Application Reference: 2025/0882.

Location: The Arbour, Beech Grove, Kingstone, Barnsley, S70 6NG.

This application seeks planning permission for the erection of a first-floor extension with rear balcony above an existing front and side extension to the application dwelling.

PROPOSED FRONT ELEVATION
SCALE 1:100

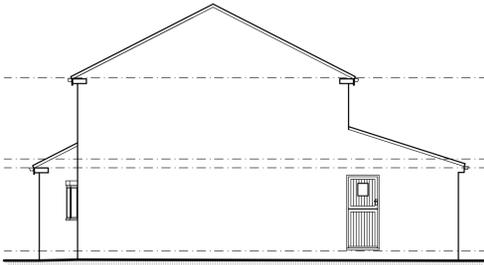
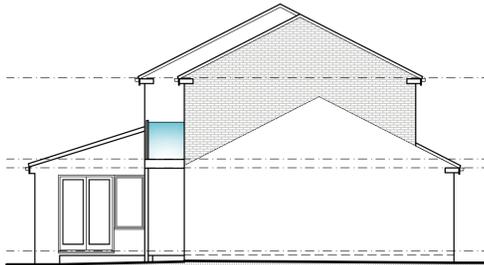
During the application process, the local planning authority (LPA) sought amendments to the roof of the proposed extension. A gable roof set down from the existing ridge was originally proposed which would normally be welcome. Unusually, in this instance, it was considered that the gable roof with a set down would result in an awkward roof junction with an unbalancing appearance. It was suggested that a gable extension in line with the existing ridge could prove more acceptable. The proposal was amended with a pitched roof and set back from the front elevation of the existing extension provided. The amended proposal is welcome and better reflects the existing character of the existing dwelling. The proposal would appear subservient and would not adopt an excessive sideways projection more than two thirds the width of the original dwelling in accordance with the Council's adopted guidance.

During the application process, the proposal was amended to provide a pitched roof a set back from the front (west) elevation of the existing extension.

BLOCK PLAN
SCALE 1:500

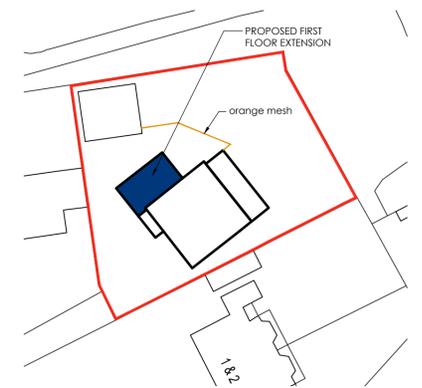
The Council's Forestry Officer was consulted, and it was stated that the proposed measures would be acceptable in principle in this instance given the layout of the development site and the nature of the proposal. However, it was suggested that a physical barrier should be implemented marking off the rear garden area because of the protected trees located there. This was added to the block plan. Consequently, no objections were received from an arboricultural perspective.
